Transport  
for NSW

**IKEA Multi-Function Logistic Unit, Marsden Park (SSD 6954)  
Notice of Exhibition**

Thank you for your letter dated 30 July 2015 inviting Transport for NSW (TfNSW) review and comment on the above development application.

TITLE:
SITE PLAN

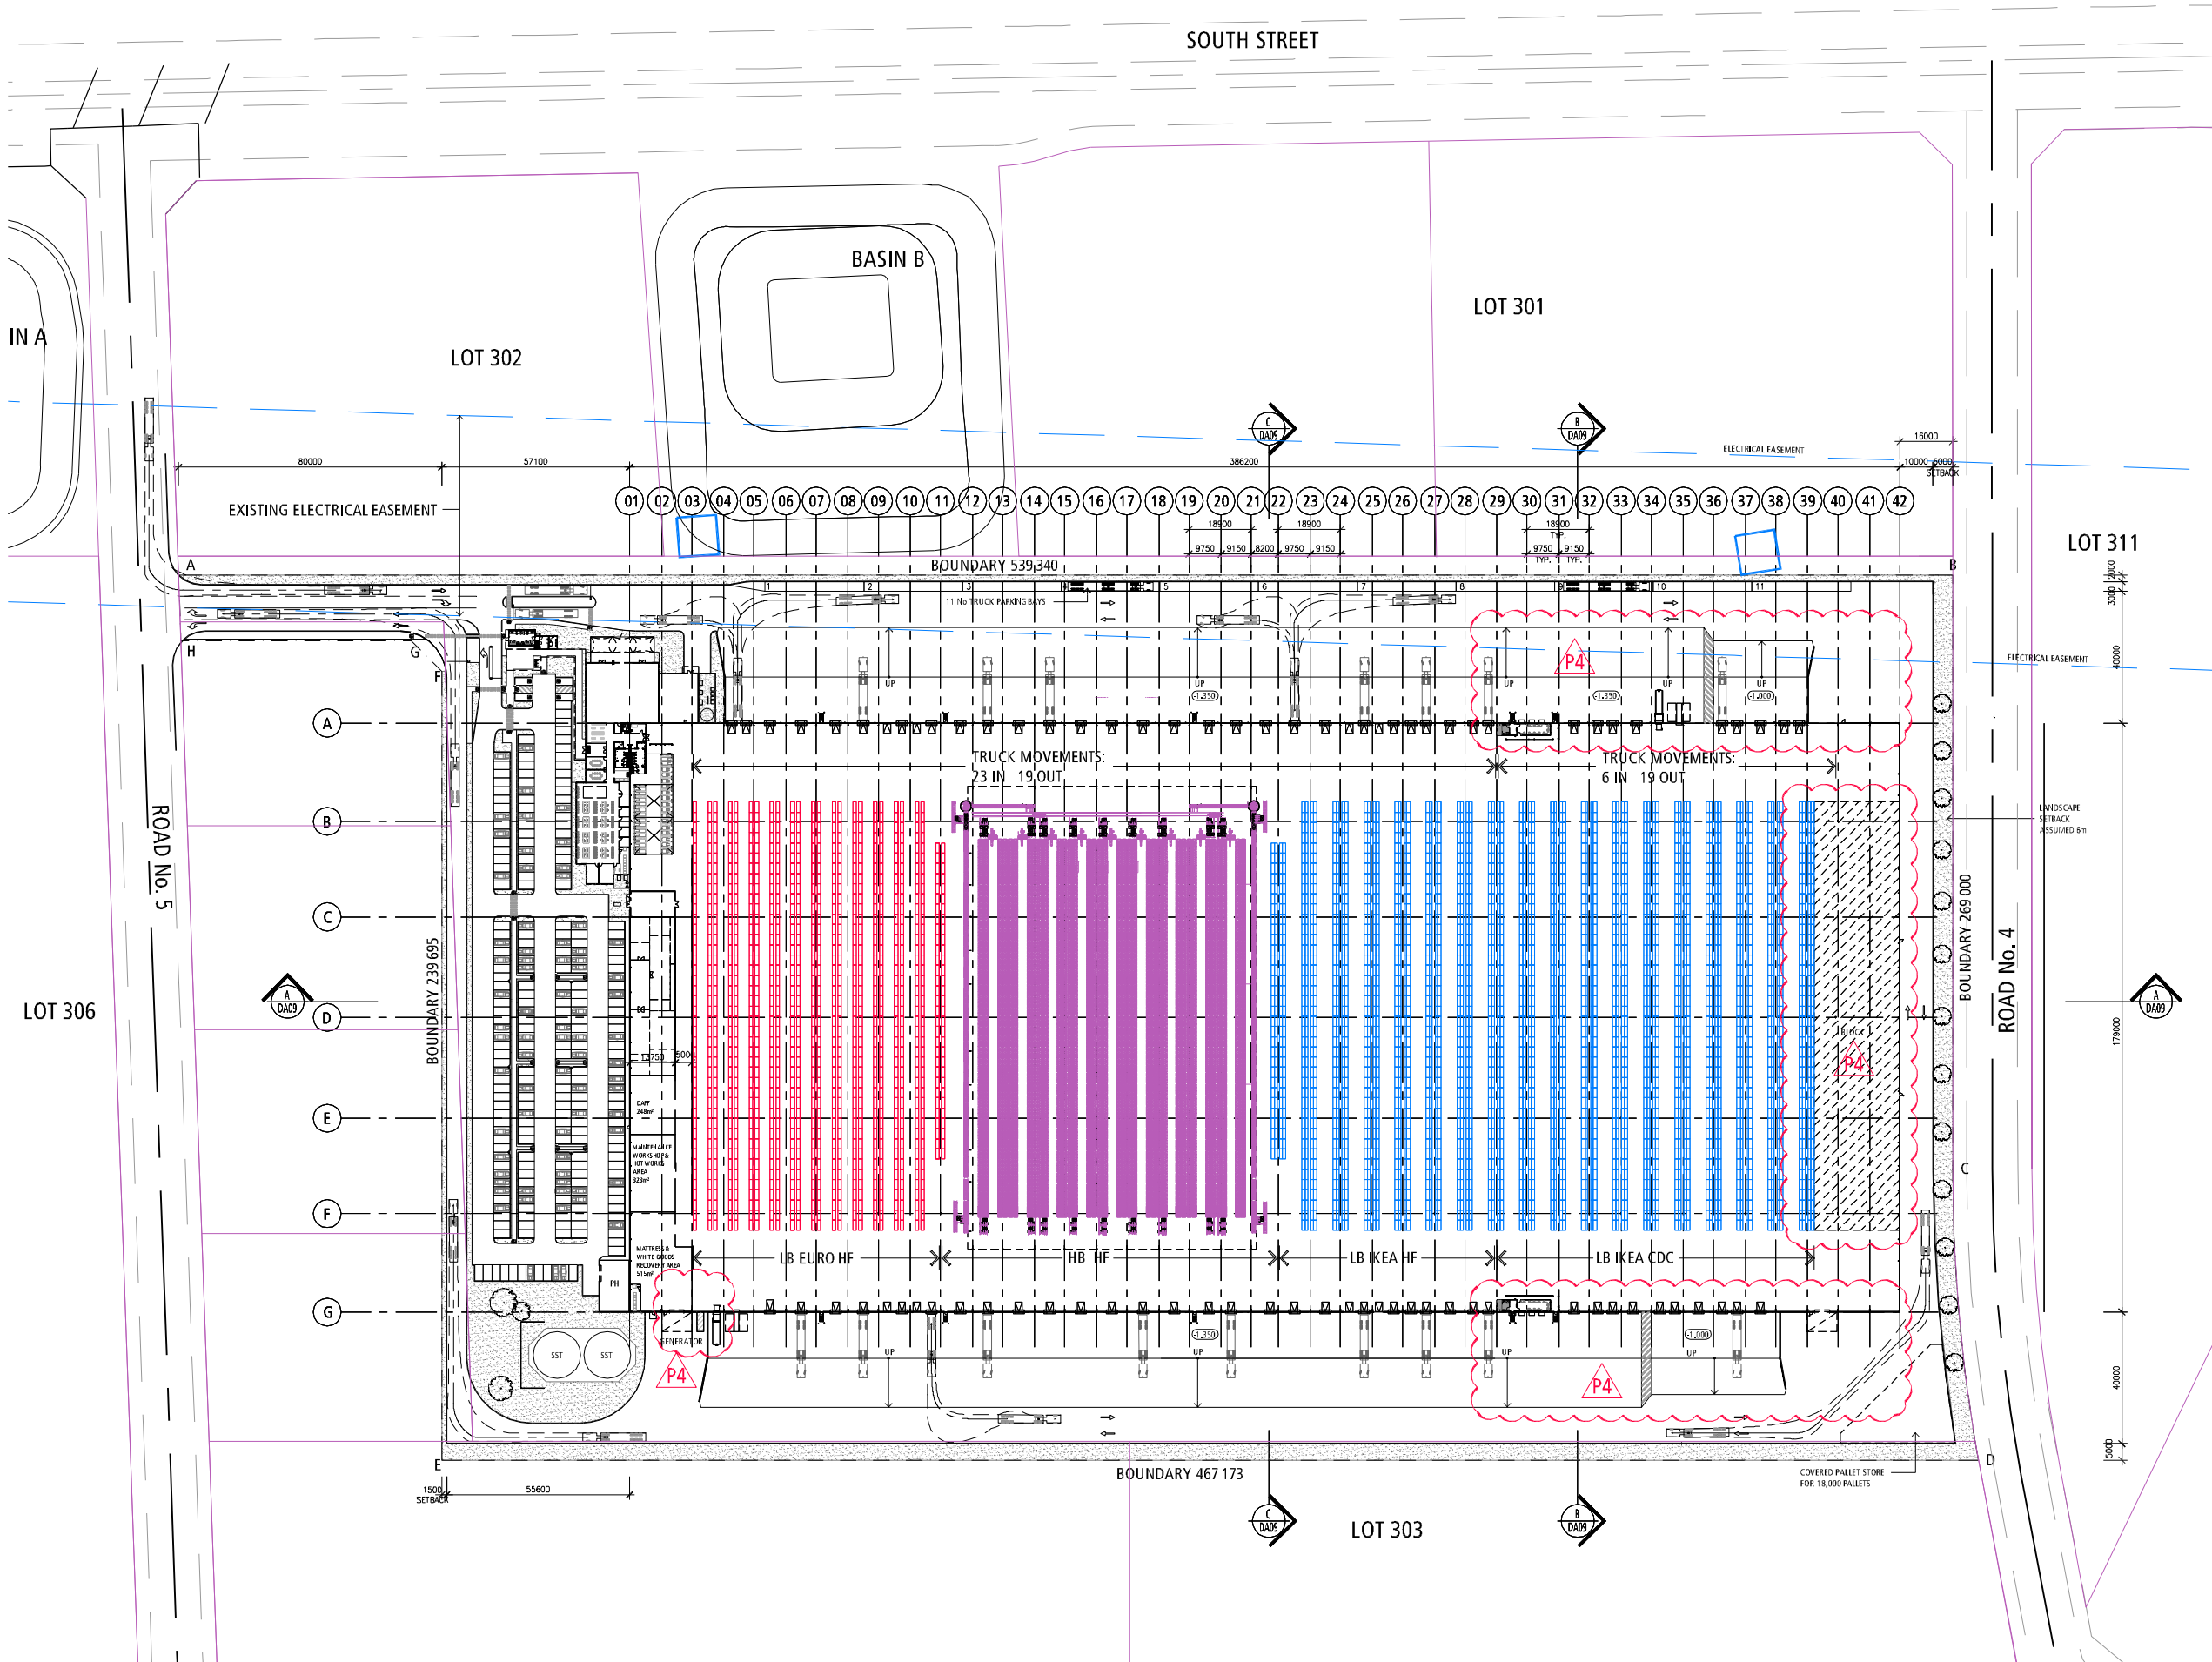
The Traffic Impact Assessment (Section 5.1.4) states that 'Neither the Blacktown DCP nor the RMS guidelines specify any requirement for motorcycle and bicycle parking for warehouses or offices'. It is therefore recommended that consideration for bicycle parking provision based on Appendix H of the Cycling Aspects to Austroads Guides (Austroads):

- Light Industry - 1 space per 1,000 m<sup>2</sup> GFA; and
- Office - 1 space per 200 m<sup>2</sup> GFA for employees and 1 space per 750 m<sup>2</sup> for visitors.

The proposed 12 bicycle parking bays is significantly less than what the Austroads guidance suggests for a 69,033 m<sup>2</sup> GFA Light Industrial Warehouse and 1,358 m<sup>2</sup> of Office.
